**KIRKLEES METROPOLITAN COUNCIL  
INVESTMENT & REGENERATION SERVICE**

**DELEGATED DECISION TO DETERMINE PLANNING APPLICATIONS**

Reference No:	<b>2024/62/90664/E</b>
Site Address:	Unit C9a Ground Floor, Carlinghow Mills, 501, Bradford Road, Batley, WF17 8LN
Description:	Change of use from offices to nursery, erection of front porch, formation of parking area and associated external alterations (within a Conservation Area).
Recommending Officer:	Nicole Helliwell

**DECISION – REFUSED**

Drawing Title:
Proposed Elevations (North&South)

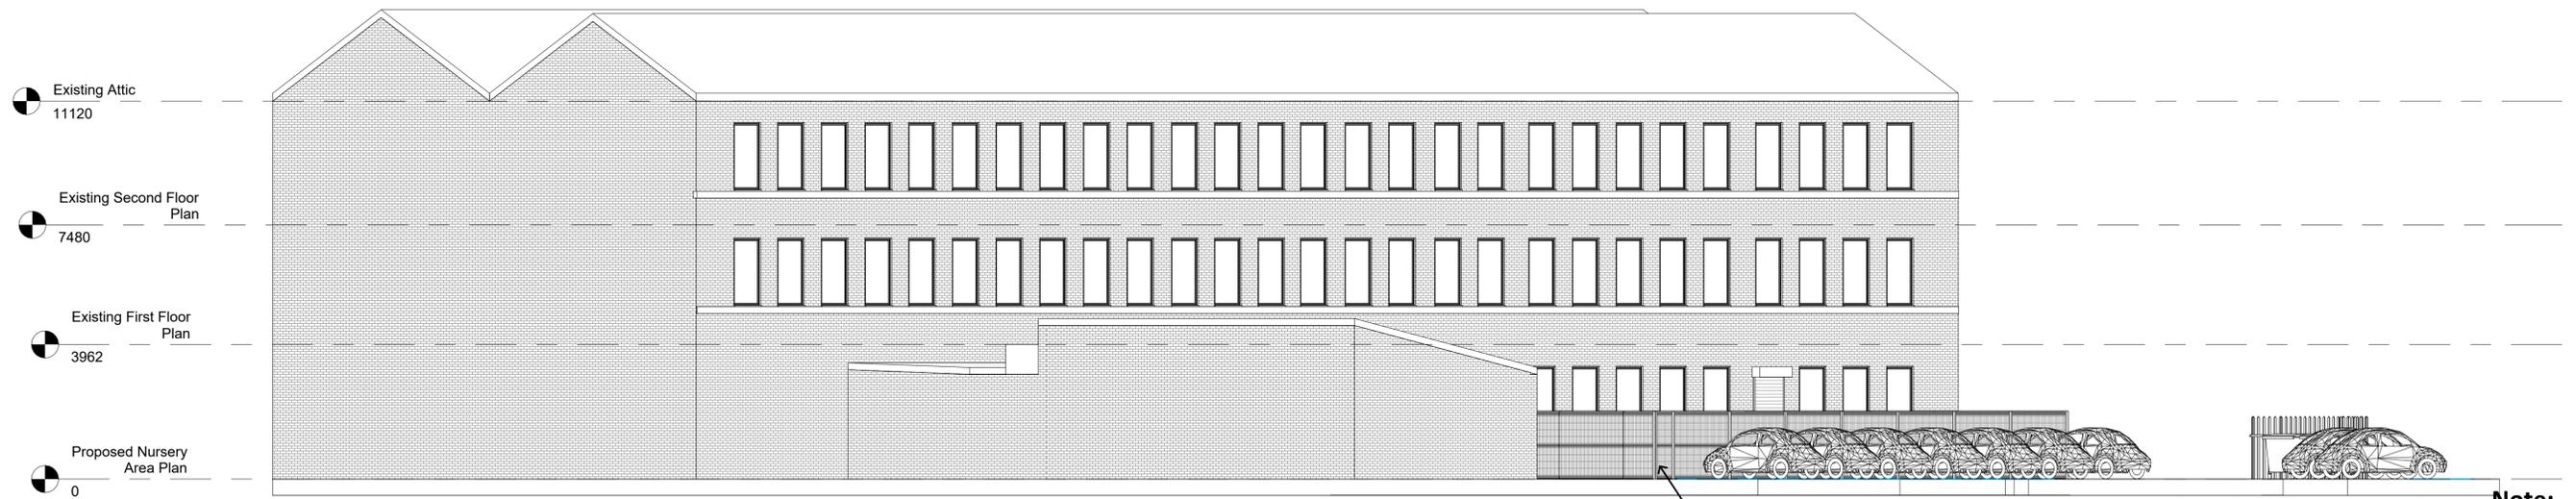
The submitted plans confirm that a fence would be erected to create a private enclosed outdoor garden area. The fence would be constructed in black timber and would measure 2m above ground level. Although the fence would have some visibility from public vantage points, it is not considered to have a detrimental impact on the character and appearance of the surrounding area given that there are a range of boundary treatments within the street scene.

KC Environmental Health have raised concerns that the use of the proposed outdoor garden area would affect the frontage of the existing adjacent units due to the associated noise from the children playing. Having reviewed this and the surrounding site, it is considered that any mitigation measures would not be satisfactory and would only give rise to further issues in relation to amenity and incompatibility with adjacent land uses. As such, it is considered that the proposal would result in a harmful impact to the adjacent businesses and the future users of the nursery which would be contrary to Policies LP52 of the Kirklees Local Plan and Chapter 15 of the National Planning Policy Framework. Given that the principle of development is not acceptable and this issue could not be addressed, no further information was sought with regard to noise.

<b>Project Name</b> Unit C9 Carlinghow Mills, 499 Bradford Road, Batley, WF17 8LL	
Drawing Title: Proposed Location And Site Plan	
Drawing Number: TR-A24-0202-006	Scale: As indicated@A1
Date: 19/03/24	Revision: 1
Drawn By: AM	Checked by: JA
Reason For Issue: Planning

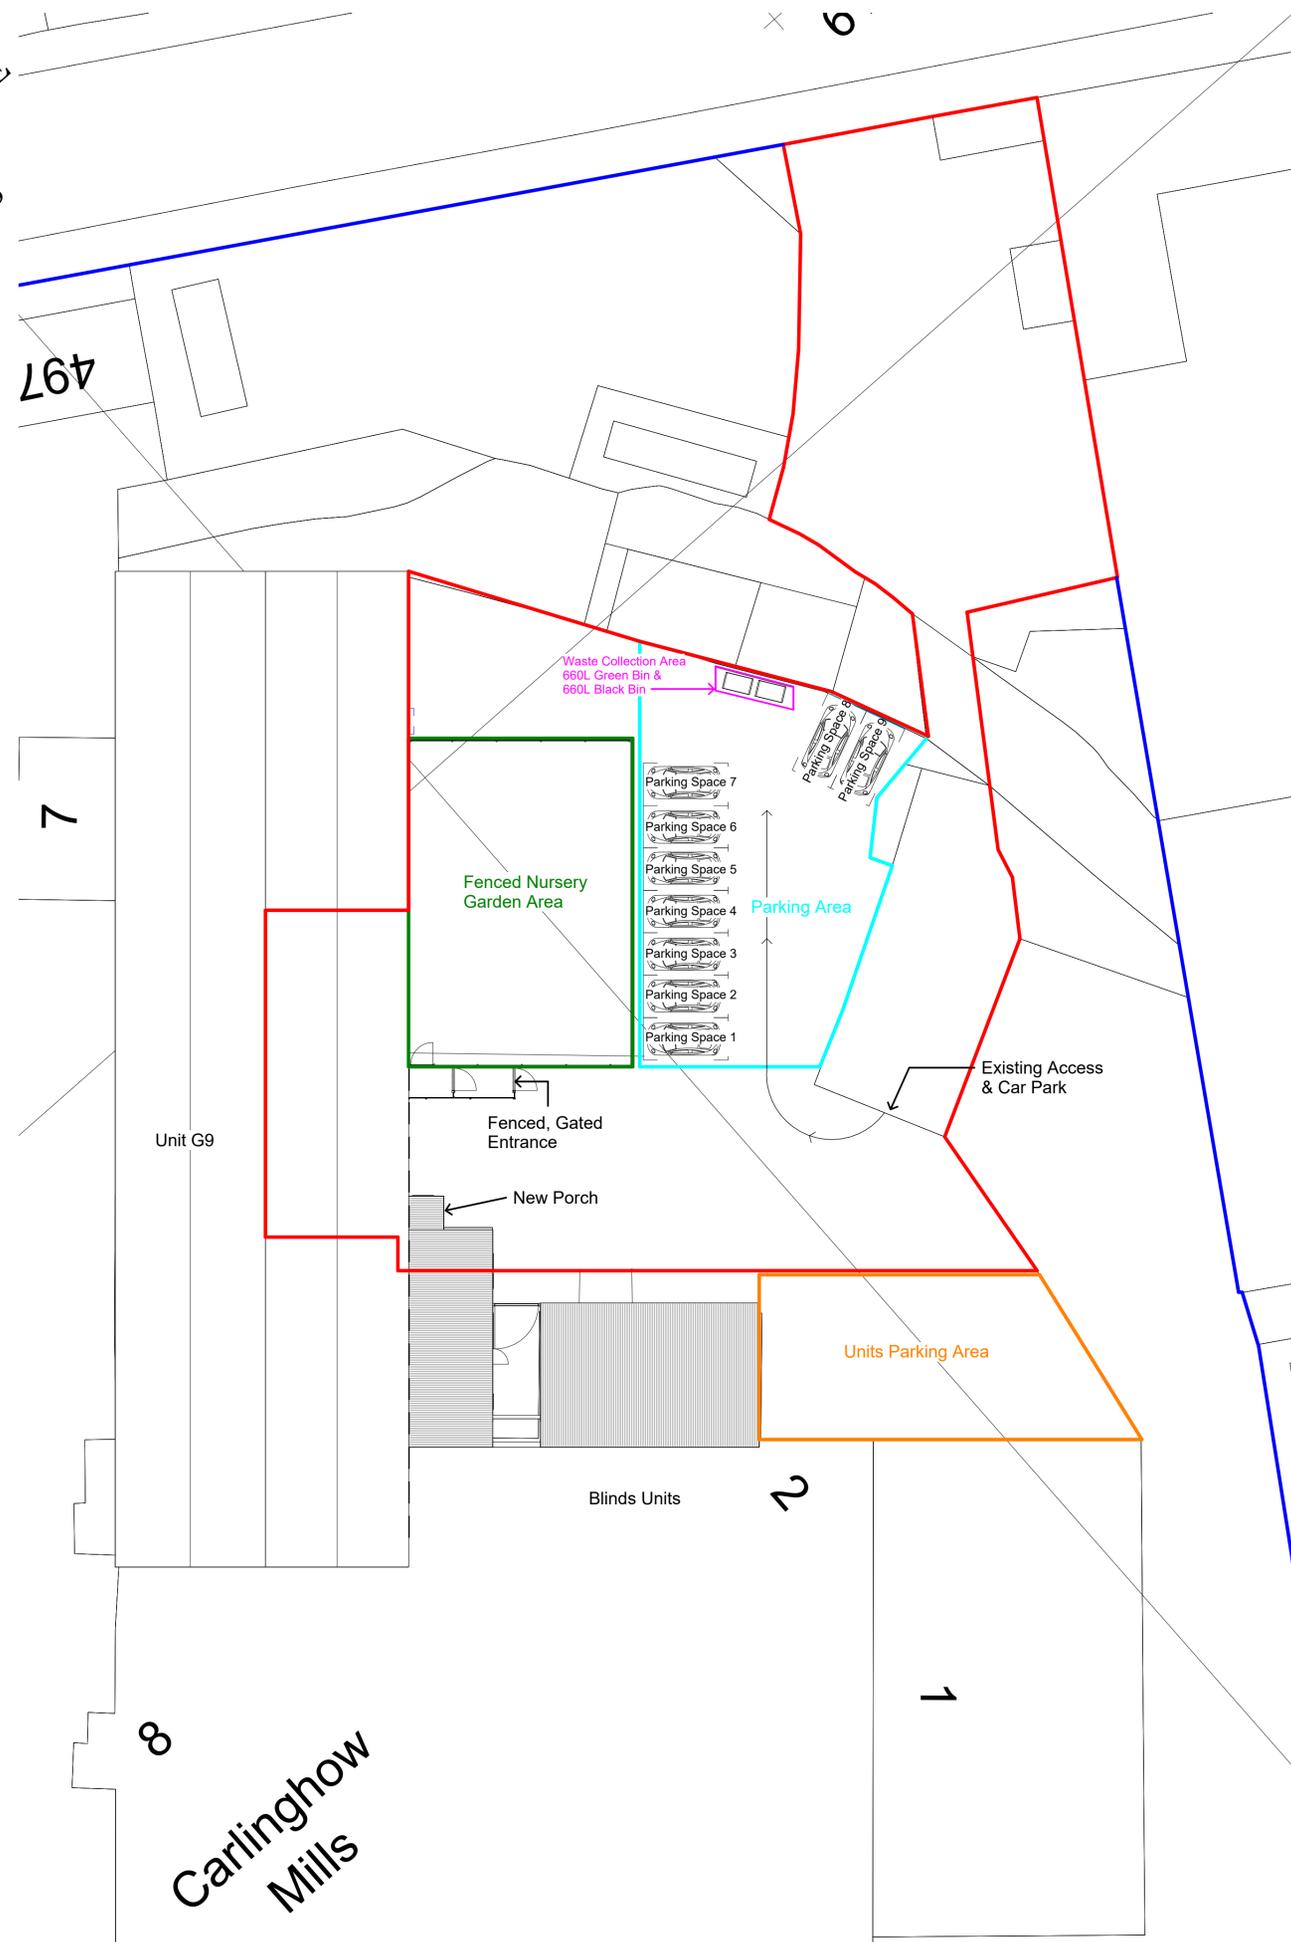
The proposal seeks to create a parking area to the east of the site. The submitted plans demonstrate that nine off road parking spaces would be created as part of the application. Although the proposal would alter the appearance of the site to a degree, it is considered that the alterations would not have a material impact on visual amenity.

The Design and Access Statement confirms that access to the site will be via the existing access from Bradford Road. The access to the main entrance of the nursery and garden will be fenced off for security and safety. The submitted plans also confirm that nine off-street parking spaces will be provided for the nursery. Whilst KC Highways Development Management have concerns regarding the lack of a pedestrian access into the site, due to the location, it is considered that most children will be taken to the nursery by
